Our ref: Blessed Carlo College, Moama (SSD-24262975)

Subject: Response to Submissions

The exhibition of the development application and environmental impact statement (EIS) for the Blessed Carlo College, Moama (SSD-24262975) ended on 07 Dec 2022.

The Department has also undertaken a preliminary assessment of the EIS and, in addition to the issues raised in agency submissions, requires the matters at **Attachment 1** be addressed in full.

Drawing
**PRECINCT MASTERPLAN -
 LEVEL 01**

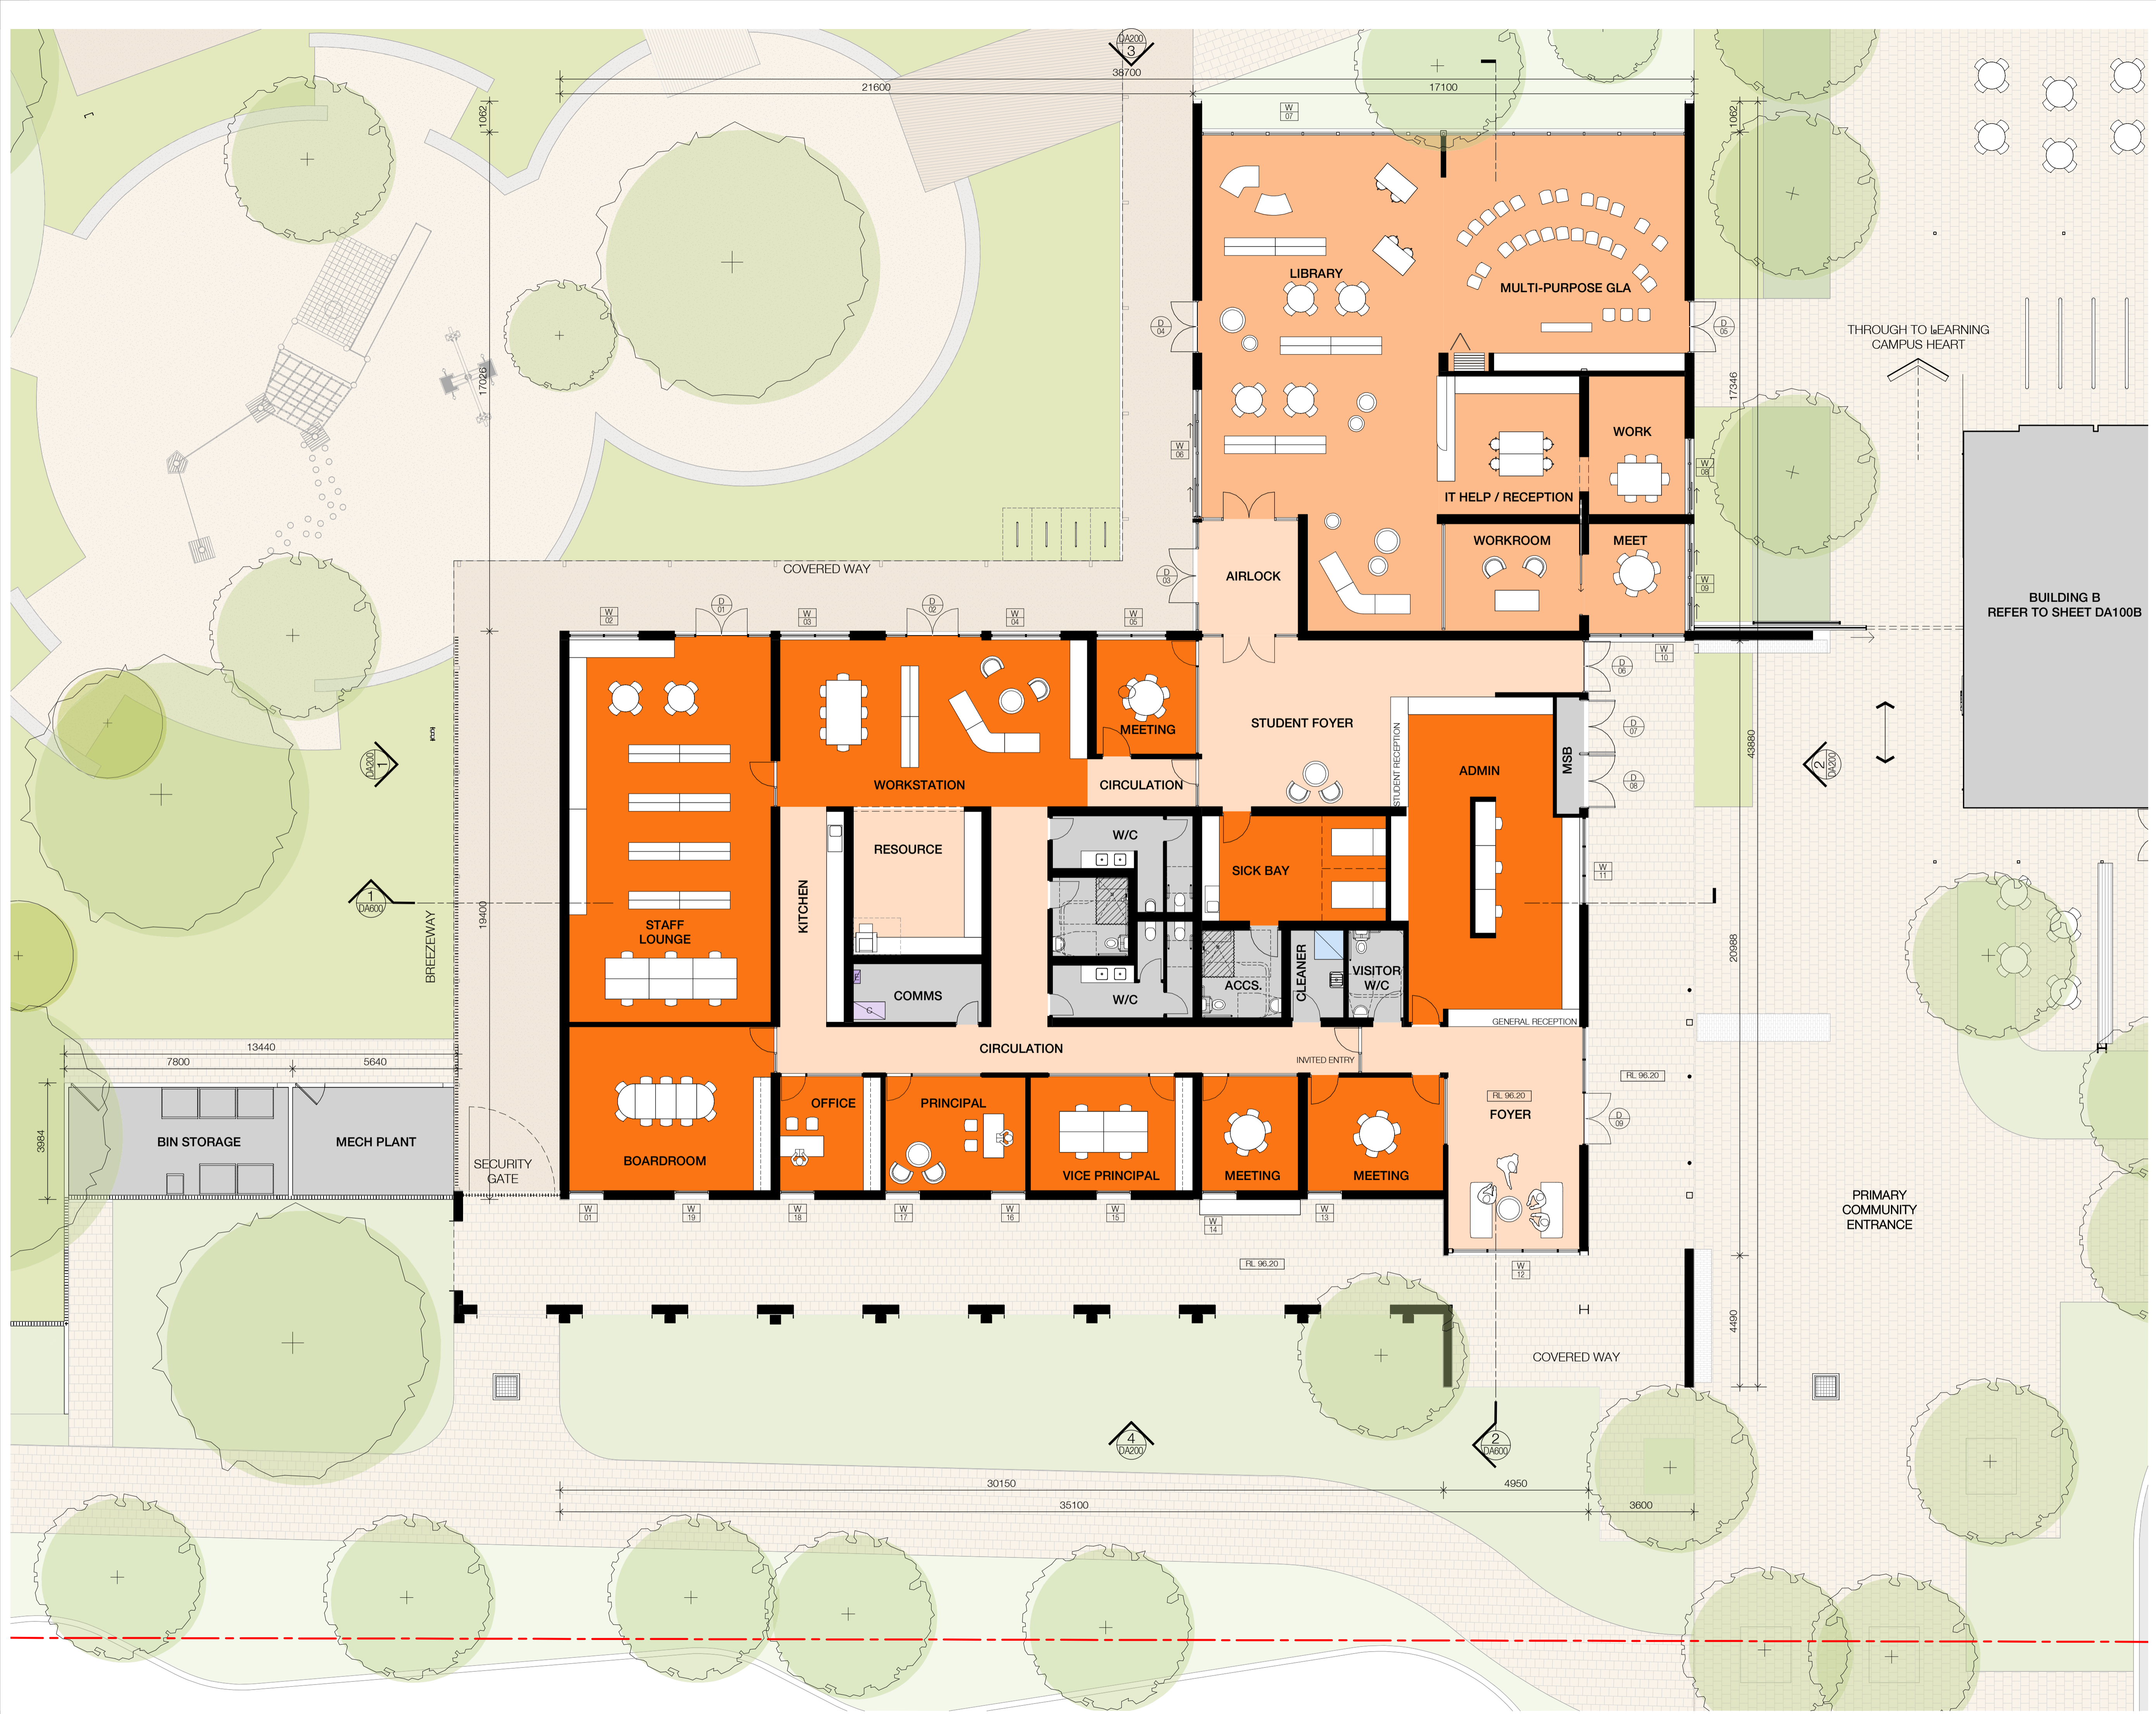
- The proposed Building C and D would encroach into the green corridor identified by the Moama Northwest Masterplan which has been preserved for opportunity for revegetation. You are required to address this issue and either amend the building layout or justify why this would be acceptable.
- The Department has reviewed the comments from the State Design Review Panel (SDRP) in its meetings (1 and 2). In the SDRP 2 meeting, the panel required that the pedestrian movements on the southern side and related matters be clarified through amended design. However, the Department notes that most of the responses state “Noted and forwarded to the design team for consideration”.
- The RtS needs to include an amended Architectural Design Report which provides clear explanation of the design response to the comments from SDRP in the previous meetings.

The car parking along with the southern boundary should be further set back from the boundary to ensure opportunities for landscaping and denser screening at the interface with the neighbouring properties.

The architectural plans/RtS should include details of the Chapel marked in the site plan.

- The internal roundabout has near-zero setback from the property. The site plan should be amended to provide a setback of this roundabout to the southern boundary to increase safety and provide opportunities of landscaping at the interface.
- The EIS refers to “Building 1, 2 and 3”. On the other hand, all drawings showing Building A, B and C. Please revise architectural drawings to rename the buildings to be consistent with the EIS.
